Fire Marshal Division

RE: Fish & Beyond
1234 N. Main St.
Lillington, NC 27546

Application Number FMFW2010-0003

PROPOSED FLOOR & LIFE SAFETY PLAN

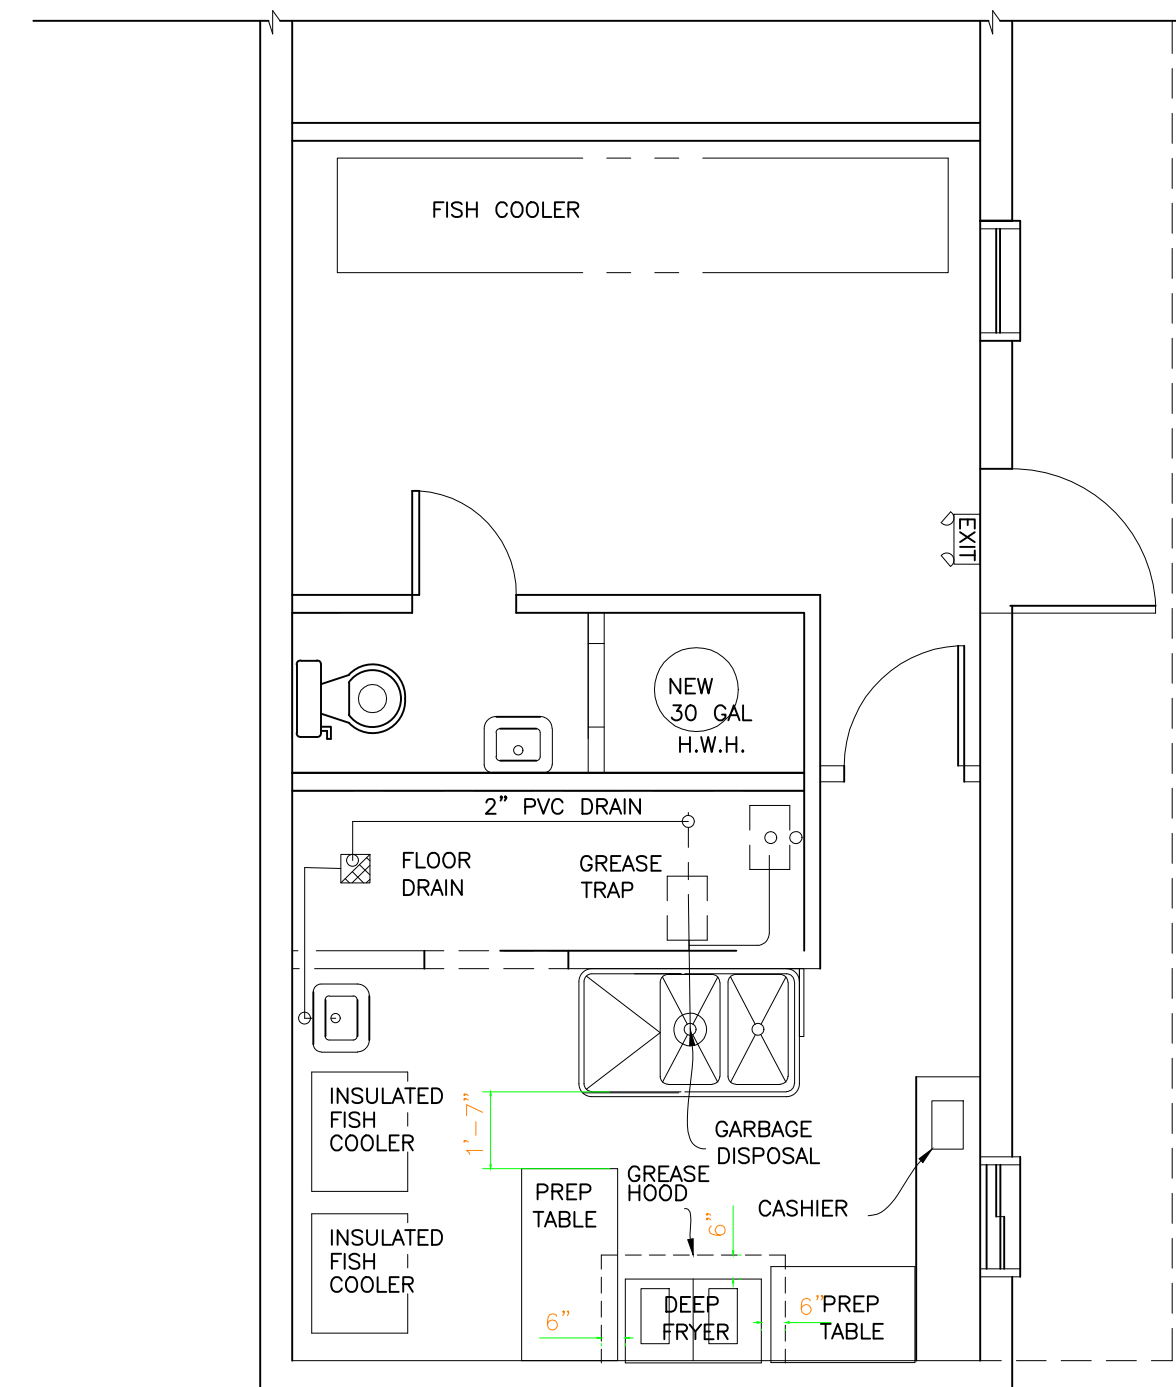
- **Fire Extinguishers**
 - Fire extinguishers shall be placed in approved locations, one in the area of the rear storage space and one in the front entrance area.
 - The fire extinguishers provided shall have a minimum rating of 2A 10B: C and shall not be installed higher than 5 feet above the finished floor.
 - In addition to the above extinguishers, a portable fire extinguisher shall be provided within a 30-foot (9144 mm) travel distance of commercial-type cooking equipment. Cooking equipment involving vegetable or animal oils and fats shall be protected by a Class K rated portable extinguisher.

- **Emergency Lighting**
 - All emergency lighting shall be in proper operating condition at time of final inspection.
 - Any changes made in illumination requirements, due to equipment placement or storage arrangements shall be addressed before final inspection.

- **Knox Box**
 - Keys for front entrance door shall be provided to be placed in the existing box installed on the premises.

- **Physical Address (ie: suite Number if Applicable)**
 - The physical address of the building shall be posted in a conspicuous place so that it can be seen on approach from the road, access road, and/or parking lot.

- The numbers used to make up the physical address shall be at least 5 inches in height.
- The physical address needs to be posted on the rear of the building also.
